Pagham Beach (Holdings) Ltd

25th October 2019

re. Town & Country Planning Act 1990 (as amended)
Application ref: P/94/19/HH - 28 Harbour Road, Pagham
Proposed single-storey extension

PROPOSED G.F. PLAN.
[1:50]

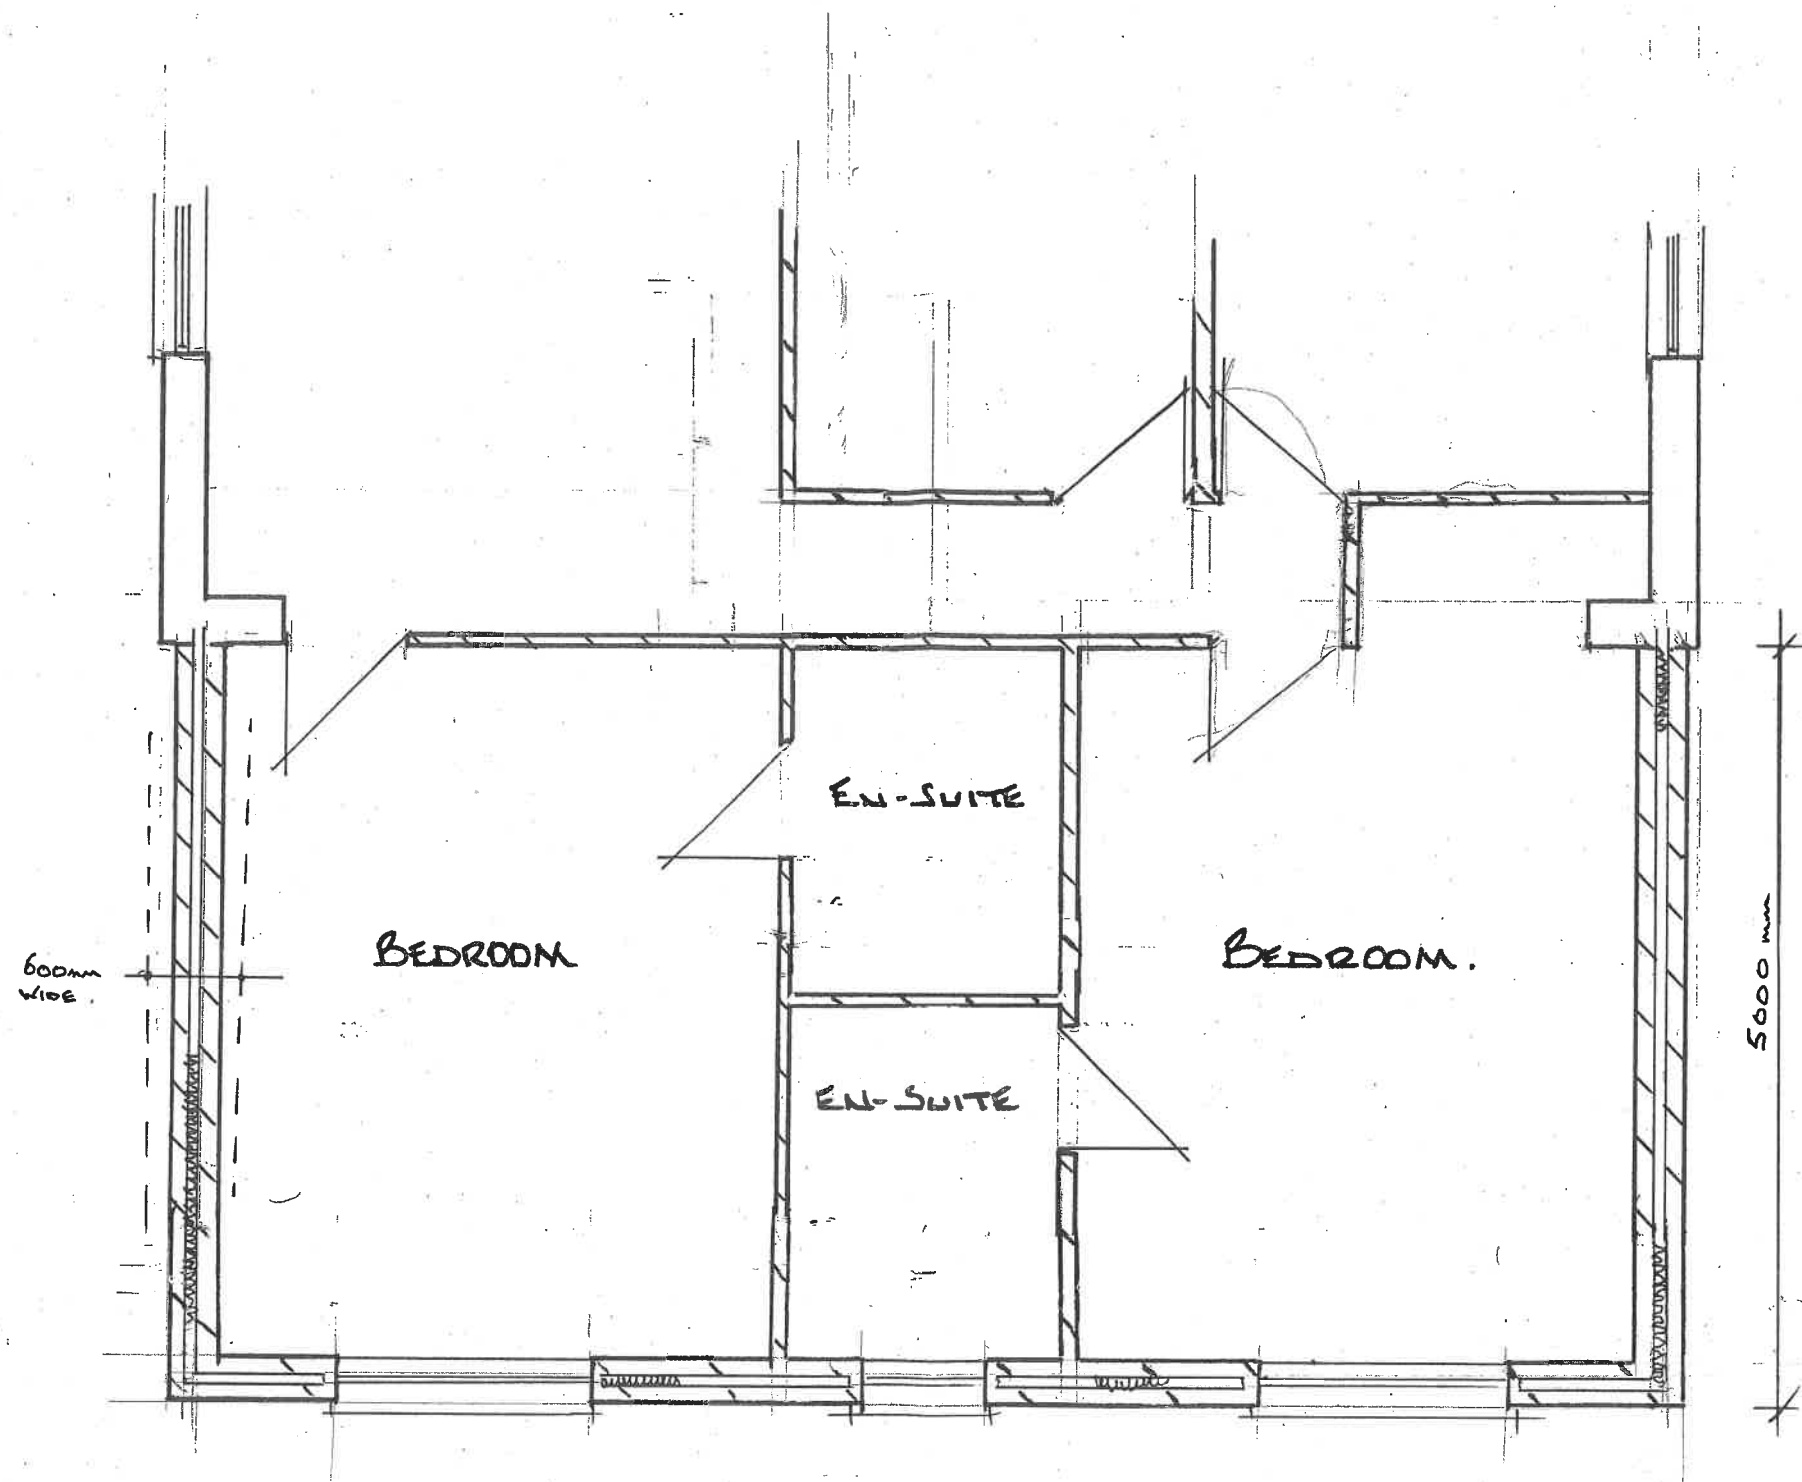
Although a Ground Floor Plan - As Existing is provided there is no Ground Floor Plan – As Proposed that shows the entire footprint of the bungalow and this should be requested. It would appear that the bungalow will be extended to accommodate 4 bedrooms, 3 bathrooms, reception room/kitchen/utility. The proposed layout shows windows to habitable rooms on the flank elevations of the bungalow which will surely result in overlooking of adjoining dwellings, which should not be permitted. The entrance to the bungalow is not clear and this should be defined; although a new entrance is shown on the Floor Plan it is not shown on the Elevations as Proposed, nor is the one into the utility. Amended and clarified Drawings should be provided.

No on-site parking is shown, and this information should be requested, and it should be established that at least two cars can park on-site and be able to turn and exit the site in a forward direction. Reversing onto Harbour Road should not be permitted.

Block Plan 1:500

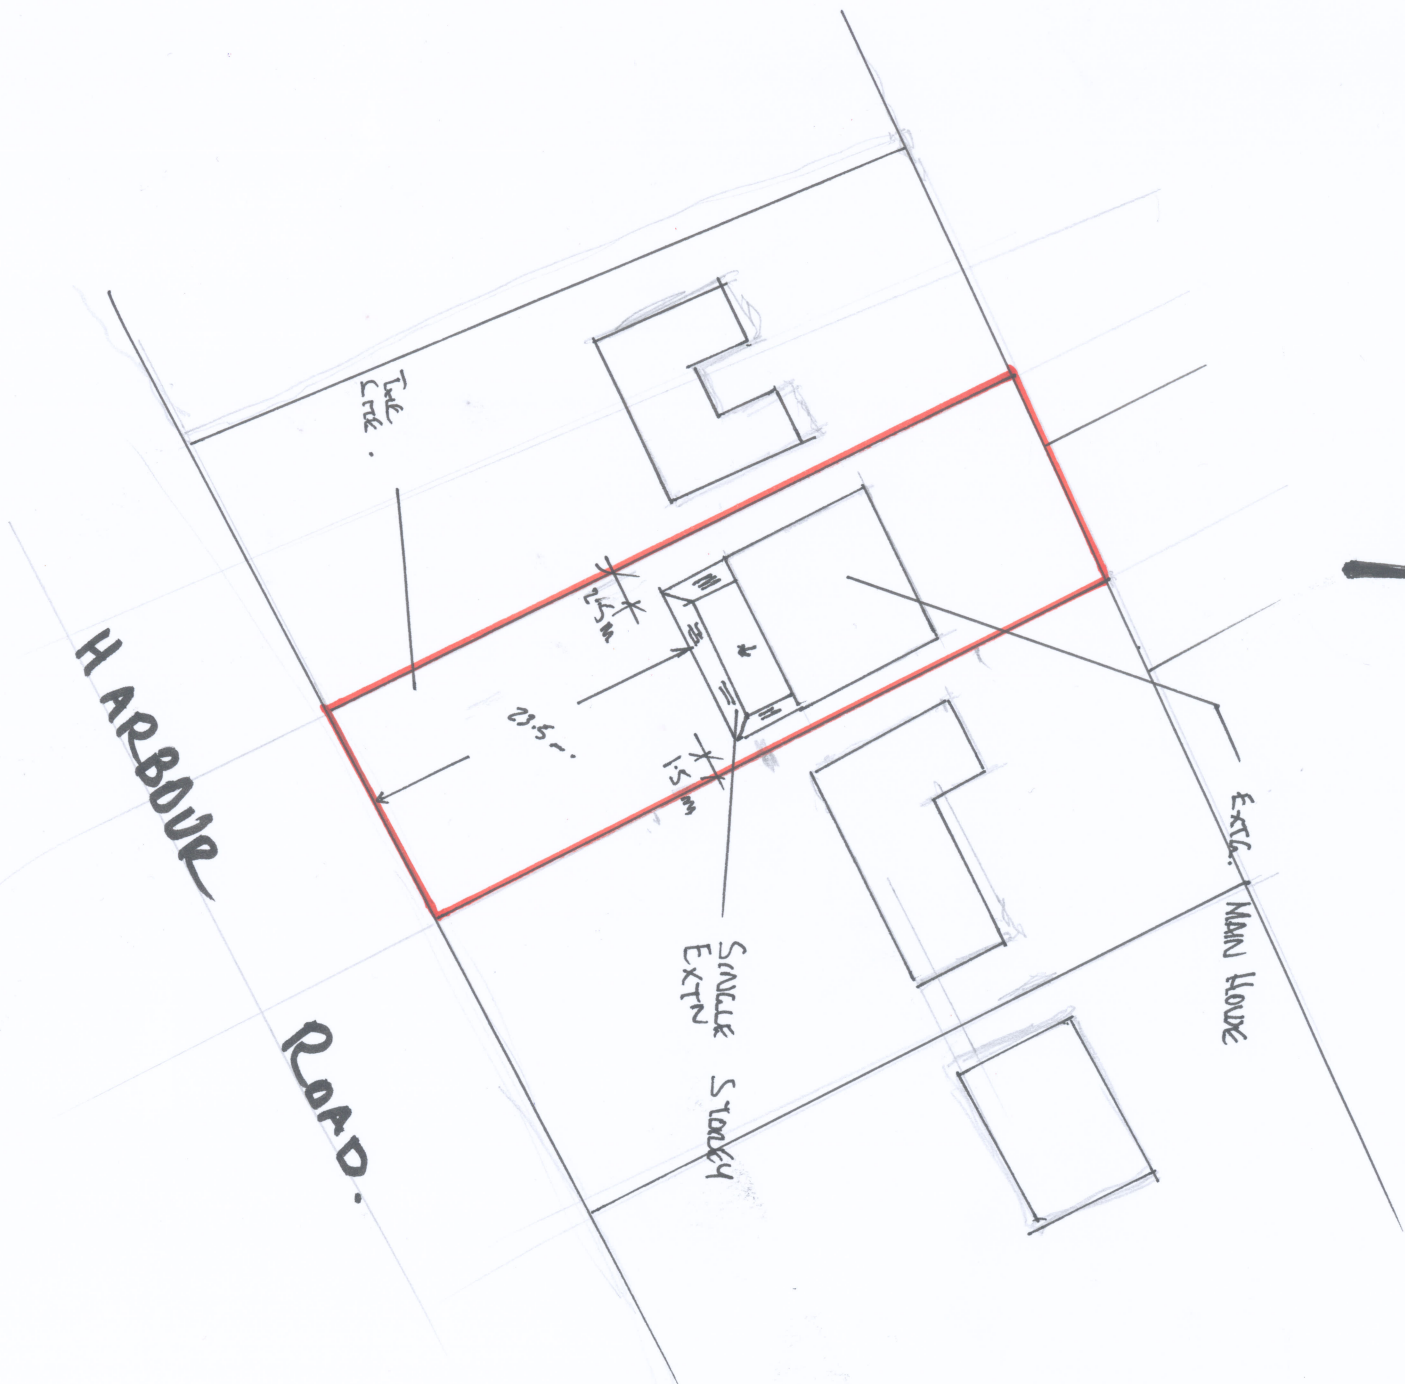
The Application Drawings include a Block Plan with the extent of the Application Site outlined in red. However, apart from defining the footprint of the original bungalow and the footprint of the extension no other information is provided on the proposed means of access to the site both pedestrian and vehicular and this should surely be provided. Please note that the subject property has frontage to Harbour Road and there are existing gates, which at present provide access. Are these proposed to be retained? There is also an unauthorised access from Lagoon Road to the rear boundary of the site, which had previous extensive vehicle storage etc. Is this access to be closed?
